# COUNTY COUNCIL'S RESPONSE TO CONSULTATION ON THE FOLLOWING DEVELOPMENT PROPOSAL

**Application no:** 19/00616/OUT

**Proposal:** The erection of up to 38 dwellings and associated access

**Location:** OS Parcel 9507 South Of 26 And Adjoining Fewcott Road Fritwell

scale	Varies@A3		
drawn	jwm	A	08-11-18
checked	ssd	Issued	
created	Nov '18	drawing no. J32-3847-PS-005

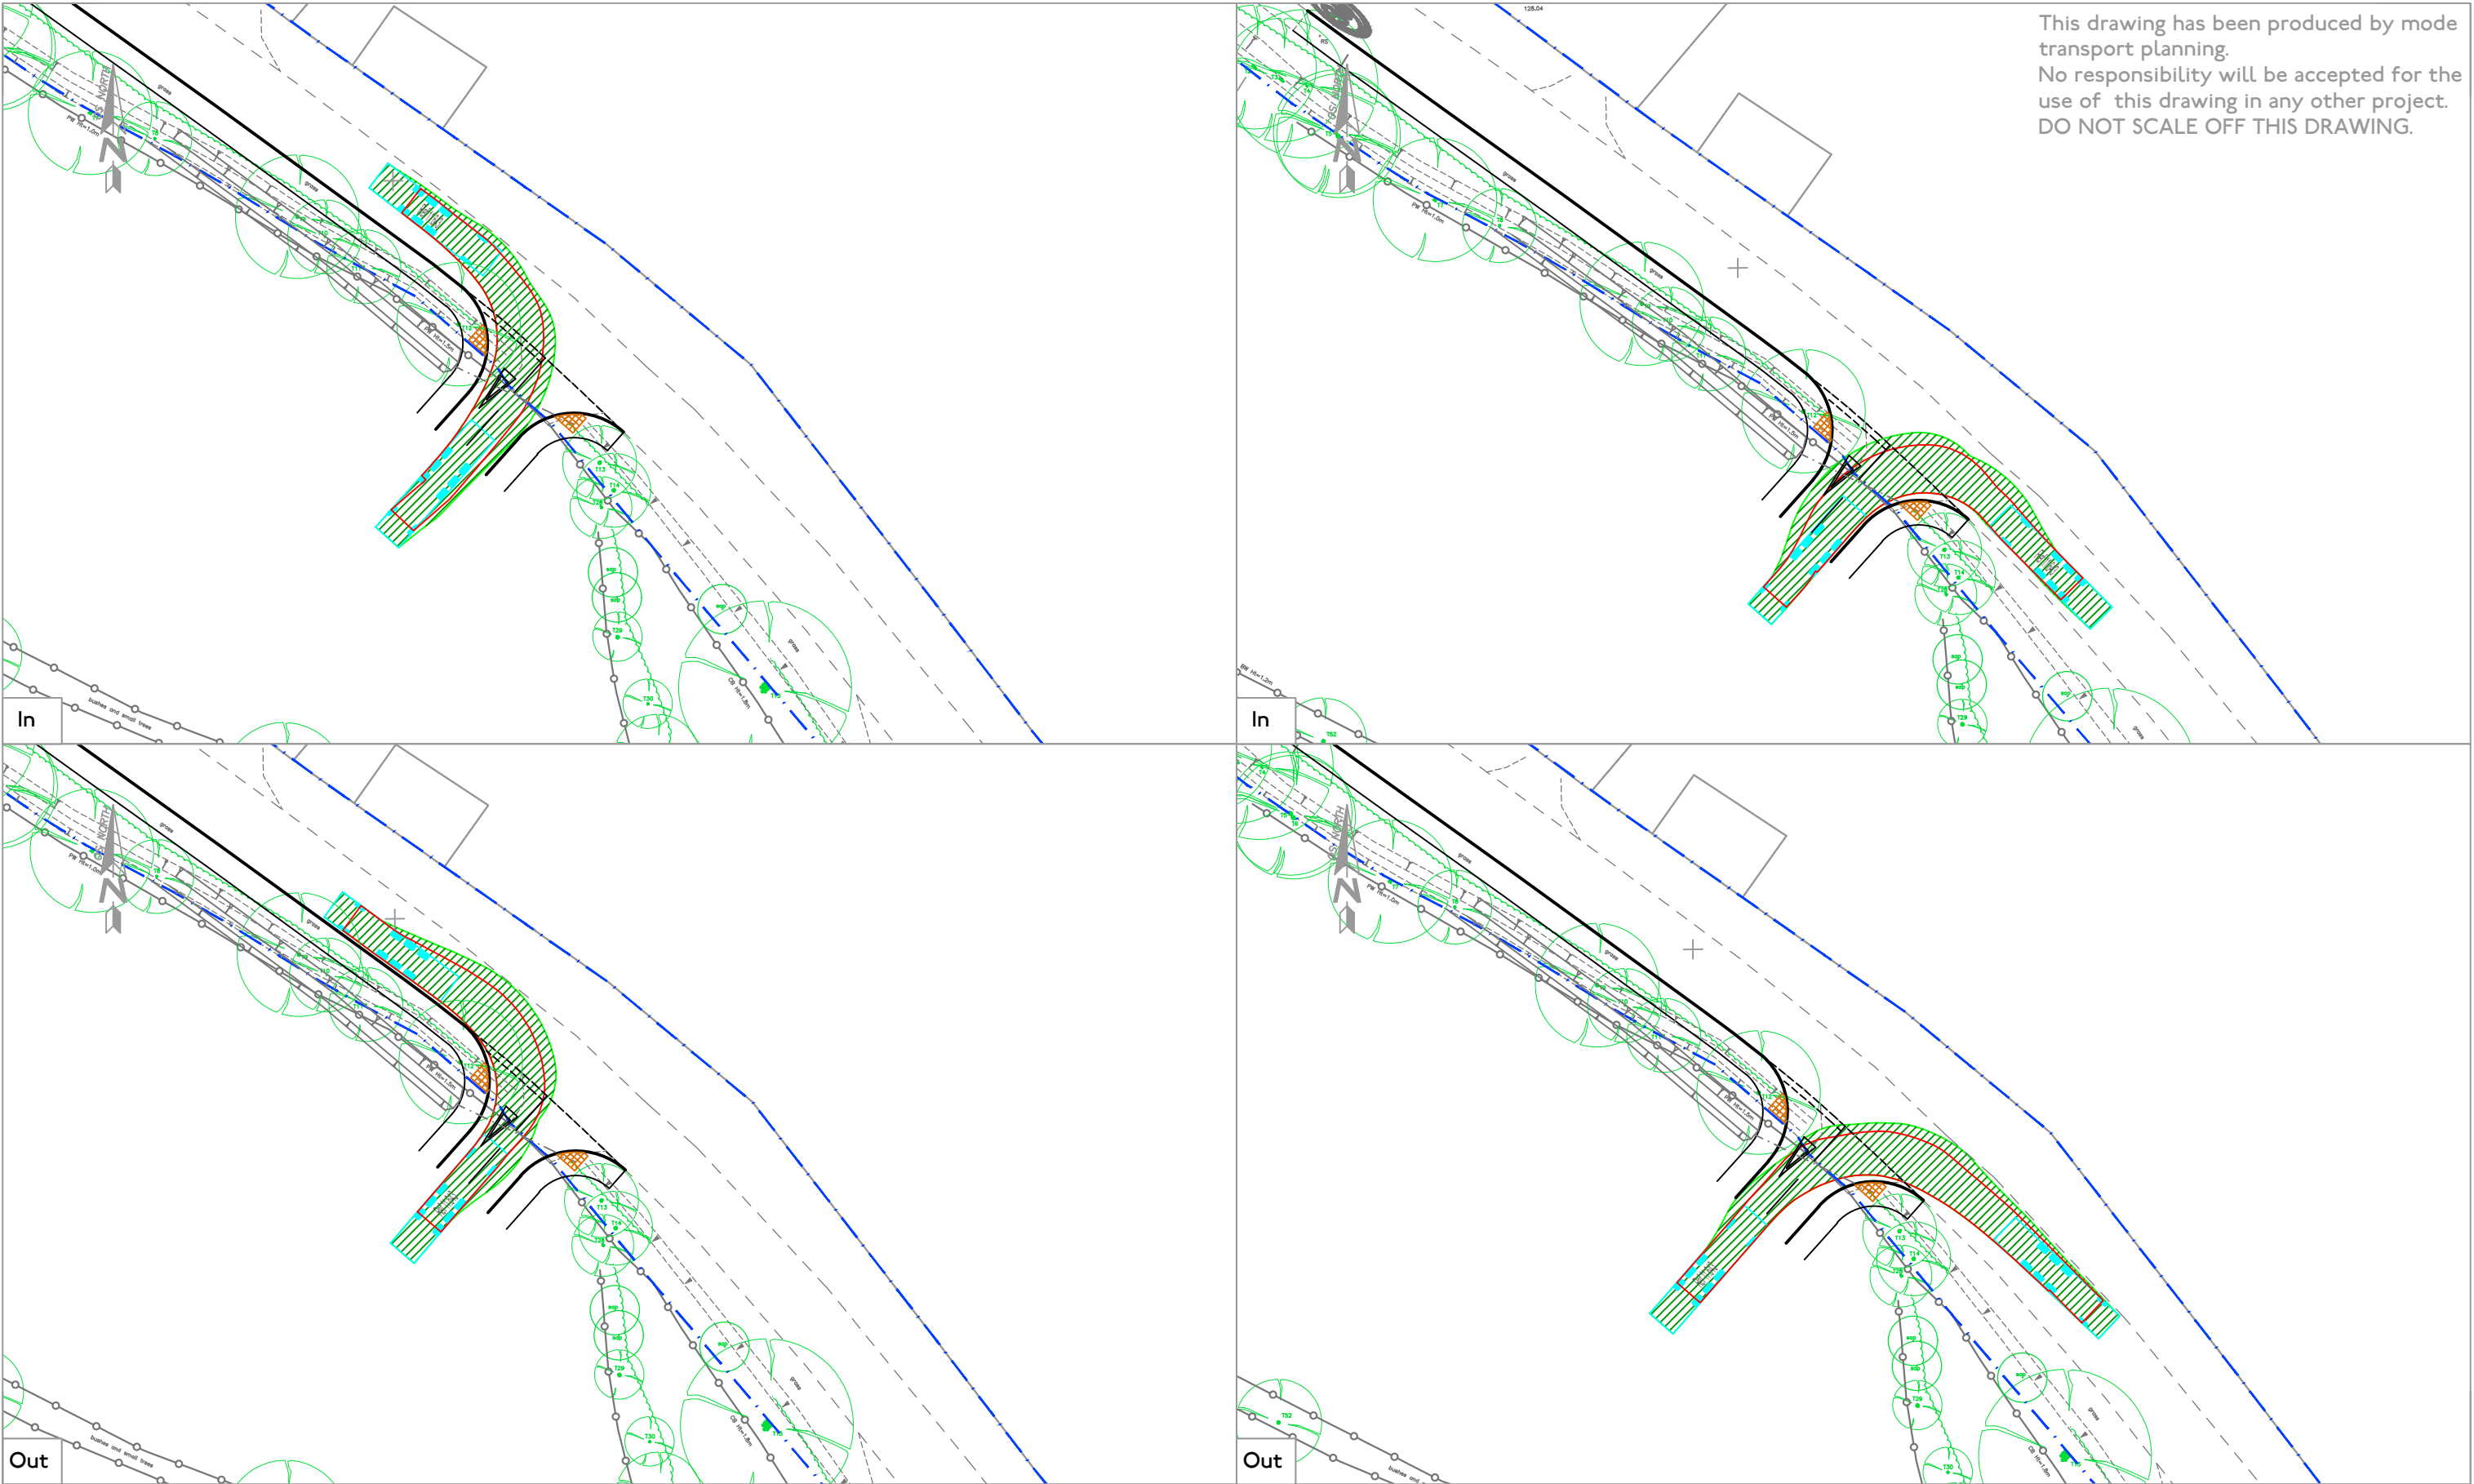
- No evidence has been provided that the proposed footpath into the development from the village of Fritwell can be delivered.
- In order to achieve the required visibility splay at the access junction no planting can occur within the hatched area shown on drawing J32-3847-PS-005 and any existing growth would need to be maintained. This hatched area does not appear to be within the site boundary or public highway and therefore there is no certainty that the visibility splay can be achieved.
- The application form states that 85 parking spaces are to be provided, however, the Transport Assessment states that only 77 spaces are to be provided, which is deemed unsuitable in a location which will rely solely on car use for the majority of residents travelling to work and for leisure.

- The applicant has shown that visibility splays of 2.4m x 215m can be achieved at the proposed site access, however, there is a planting in areas which does not appear to be within the site boundary or publicly maintained land. There are therefore no assurances that the visibility splay can be maintained.

Following comments from previous application 16/01594/F which stated that due to the fact that the reduction in speed limit required consultation and cannot therefore be certain, the applicant must show that the visibility splays must be based on 60mph. The access has been moved slightly towards the village and visibility splays of 2.4m x 215m have been provided, however, the splay goes across land which is not dedicated as public highway and does not fall within the site boundary.

As neither the applicant or the county council have control of the planting in this area, adequate visibility cannot be achieved and as such safe and suitable access into the site cannot be achieved. As such, Oxfordshire County Council recommend refusal on highway safety grounds.

Typical Street Section - Primary Road

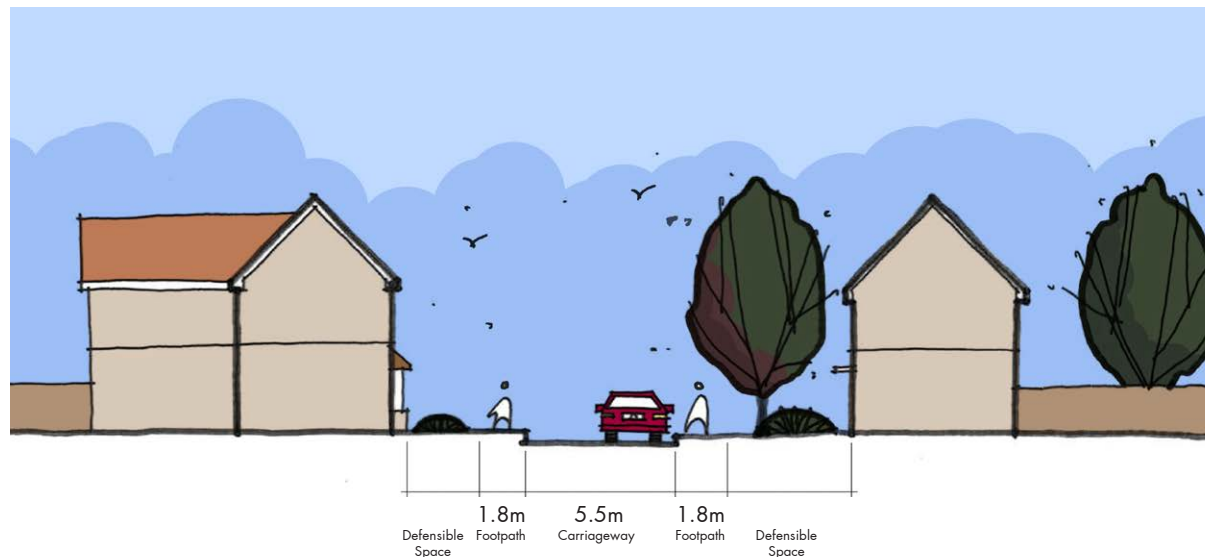
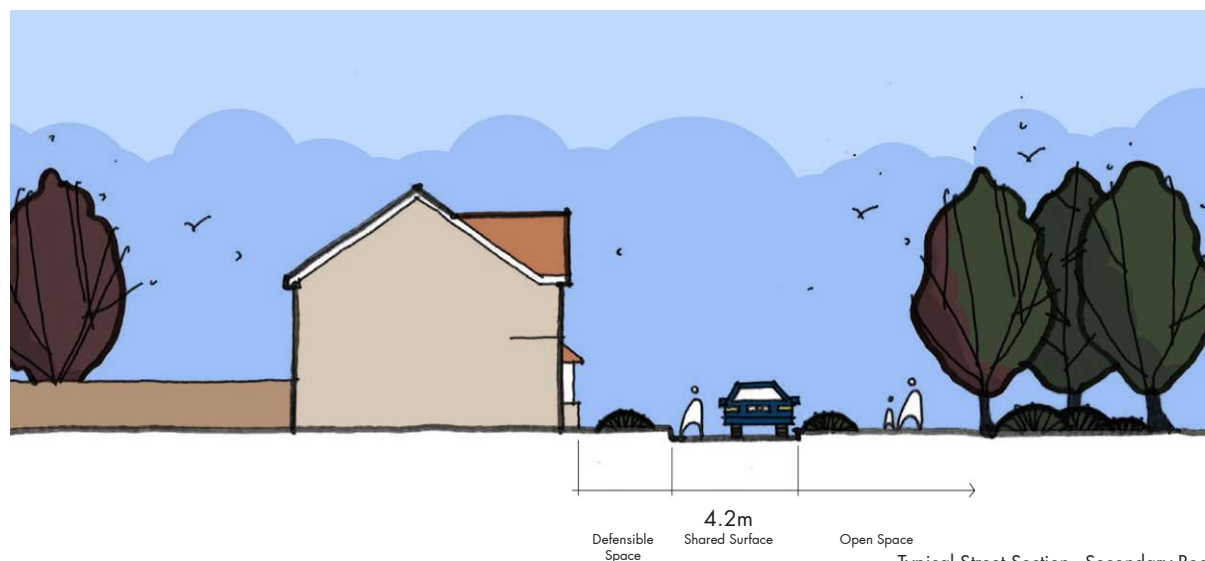
- On-site carriageway widths are insufficient and will need to be widened in order to allow to 2 vehicles to pass whilst allowing adequate space for pedestrians. Space is also needed to allow refuse/servicing vehicles to pass cars parked on the carriageway which is likely to occur if further parking provision is not added.

- A 4.2m wide shared surface is not really appropriate. Desirable shared surface is 6m, however a minimum of 4.8m should be provided to ensure two-way traffic can pass and provide space for pedestrians.
